**M1 Pacific Motorway extension to Raymond Terrace (SSI 7319)
Advice on the Environmental Impact Statement (EIS)**

Thank you for the request for advice from Public Authority Consultation (PAE-24749572), requesting the review by the NSW Environment Protection Authority (EPA) of the Environmental Impact Statement (EIS) for the proposed M1 Pacific Motorway extension to Raymond Terrace (Application SSI-7319).

ATTACHMENT A: EPA COMMENT ON EIS FOR M1 PACIFIC MOTORWAY EXTENSION TO RAYMOND TERRACE (SSI 7319)

Location: L16 - 44 Sapphire Drive, Tarro

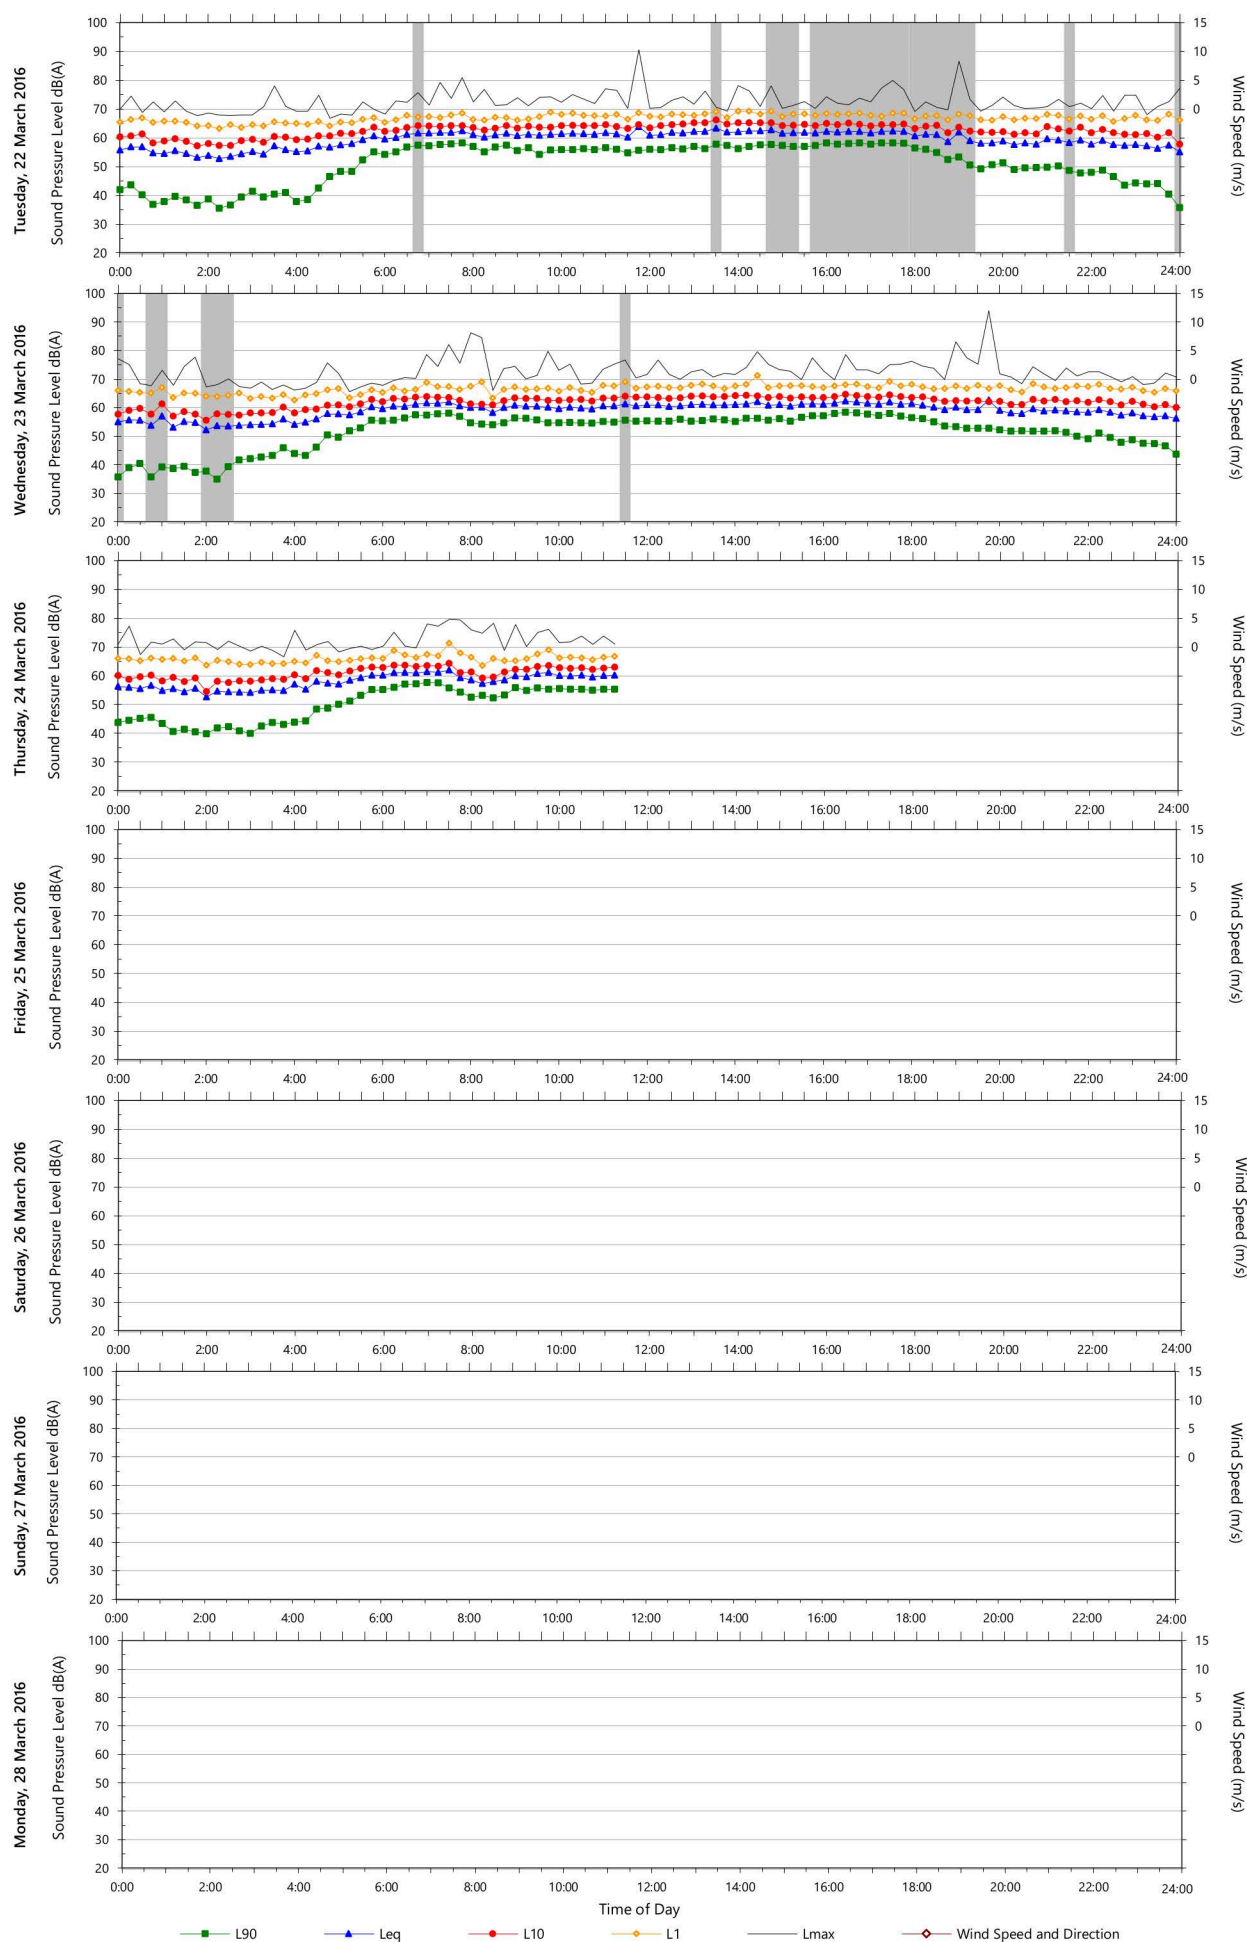
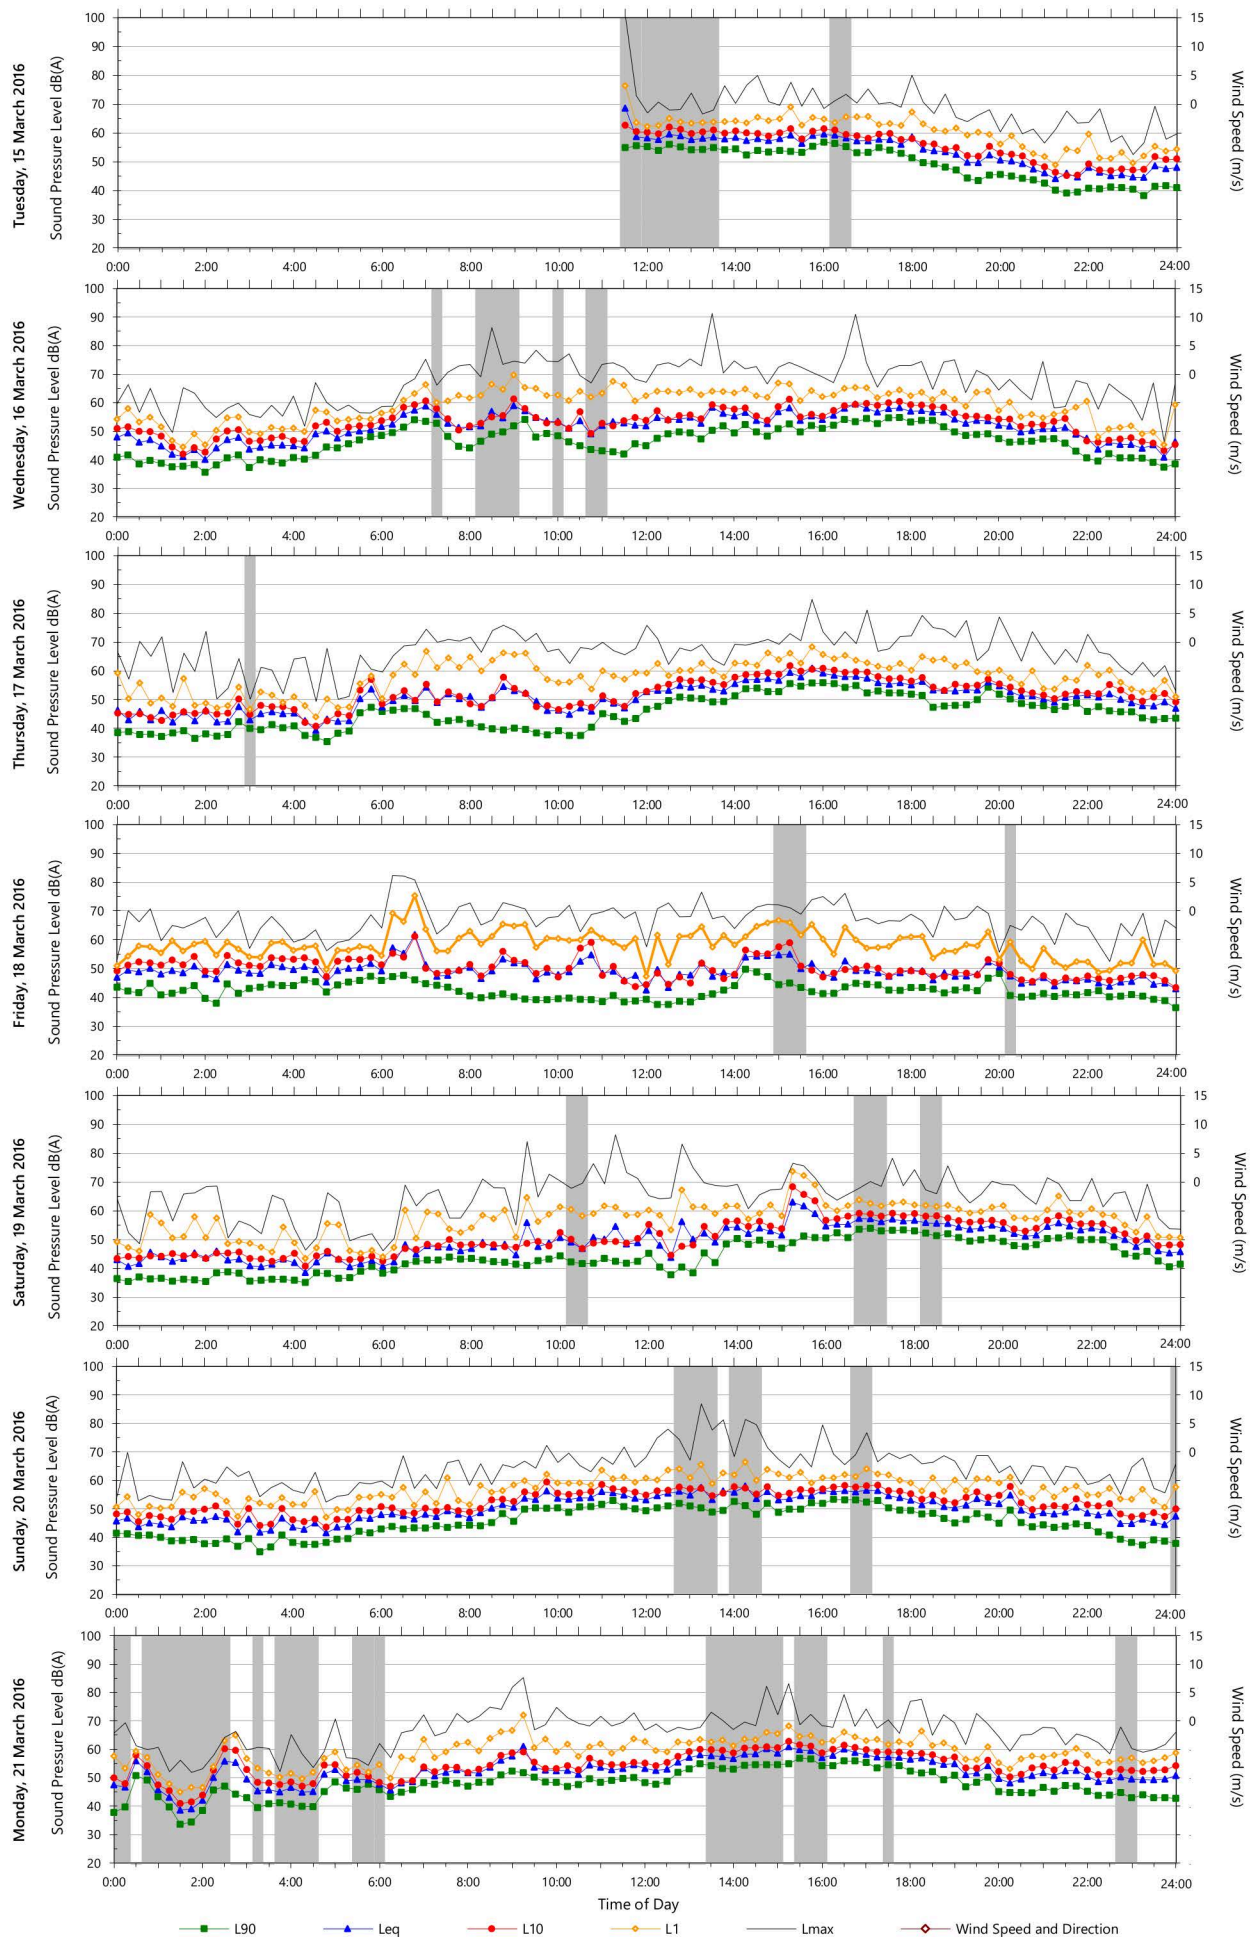
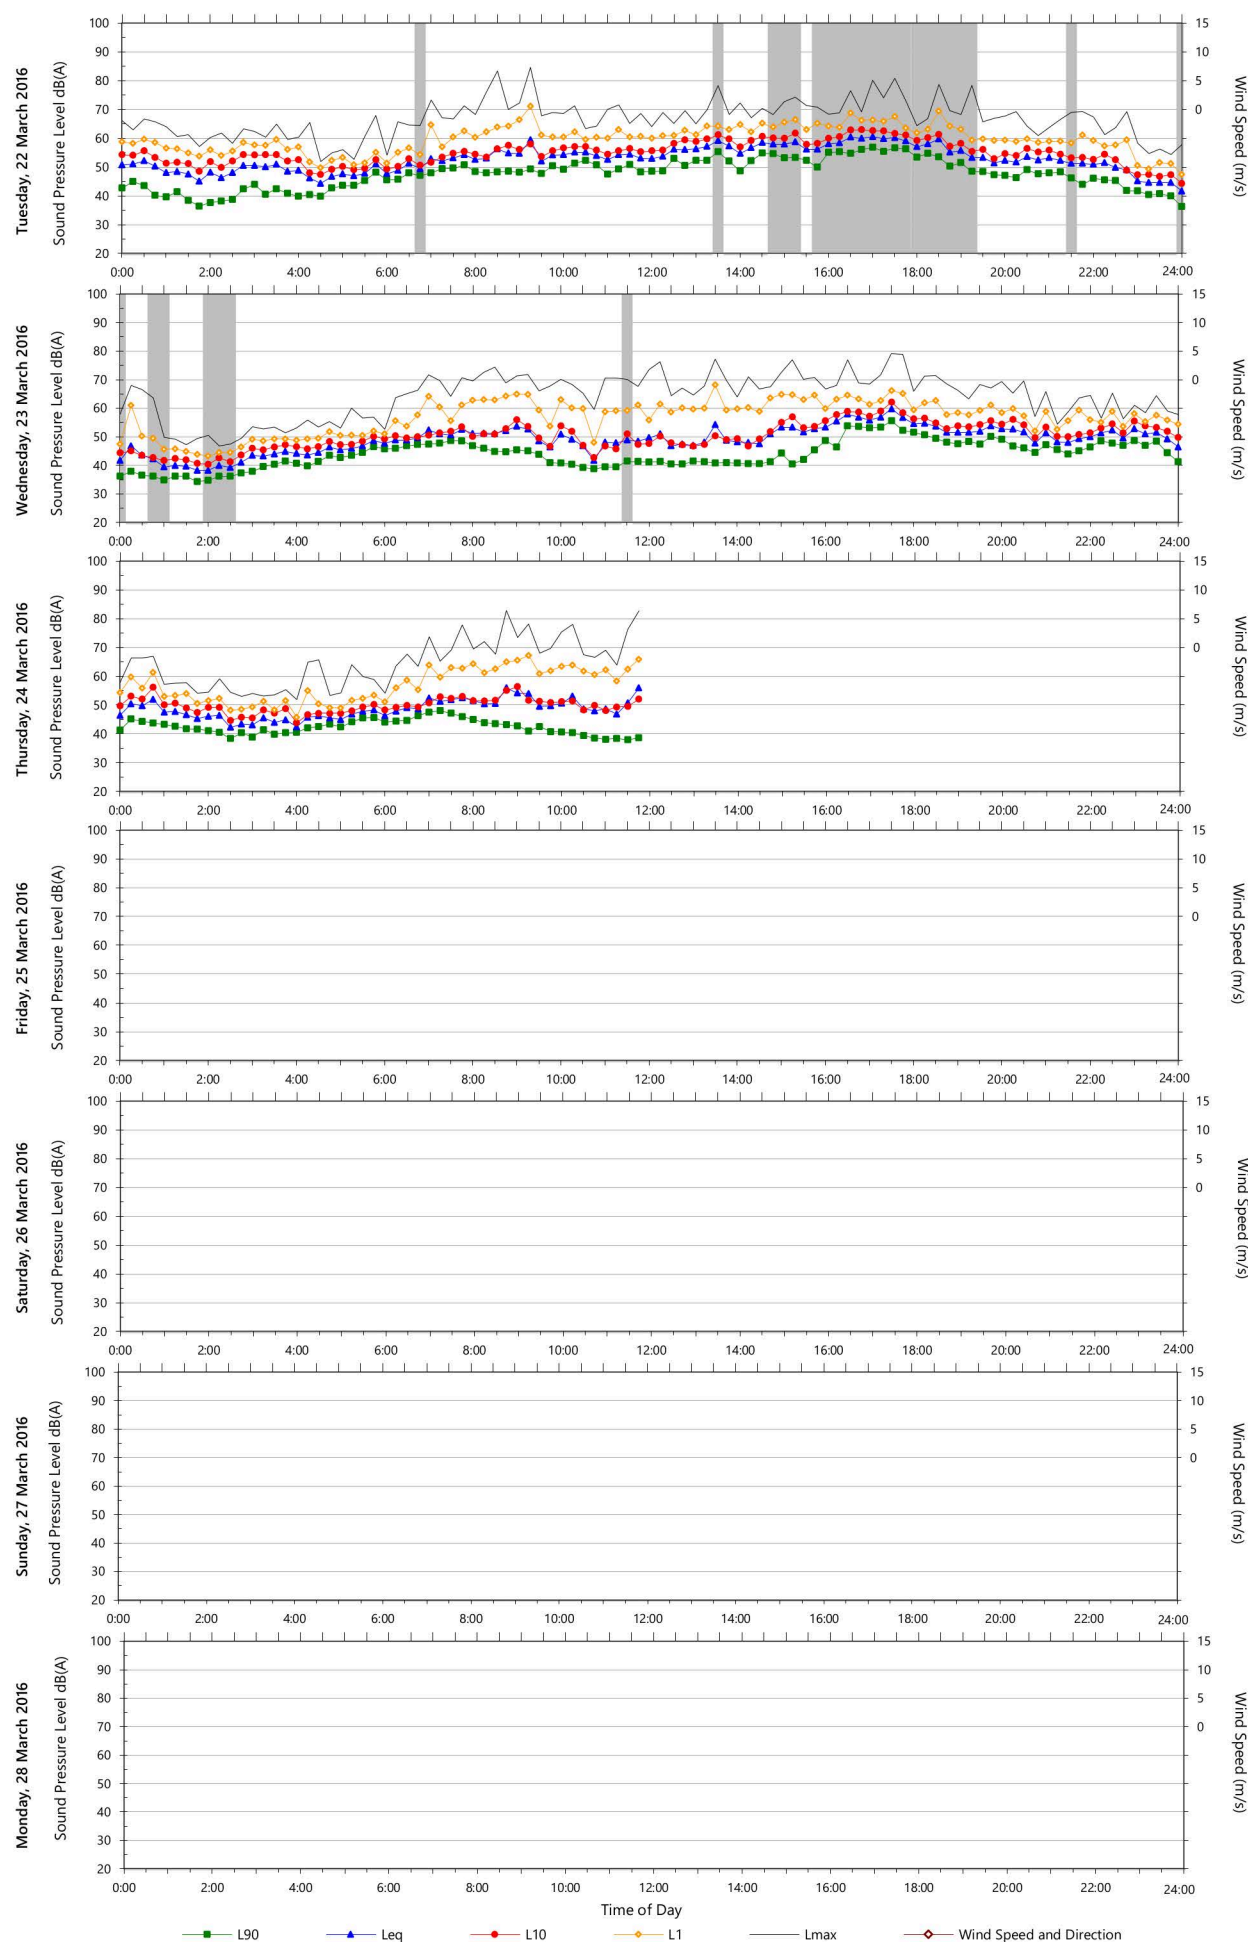
Locations L01 to L014 (inclusive) appear to have no more than 5 and in some cases less than 3 valid periods out of the total monitoring duration. Locations L15 to L20 appear to be less affected, however there it is still not clear if sufficient valid data has been presented.

Noise monitoring was also conducted in 2016 for the purposes of measuring road traffic noise. Due to the amount of data excluded at Locations L13 to L20, further justification is needed that the remaining data, after invalid samples were excluded, provides sufficient amount of data to enable a representative calculation of the traffic noise descriptors.

The proponent reviews the noise monitoring data in the NIA in the context of the monitoring requirements set out in the NPfI and for each location and either:

- Provide a justification and demonstrate that the requirements of the NPfl have been fulfilled; or
- Provide additional data that fulfills the monitoring requirements in the NPfl.

The EPA also recommends that the proponent either:

- Provides justification and demonstrate that the data presented for road traffic noise descriptors is sufficient to be representative; or
- Provides additional valid data.
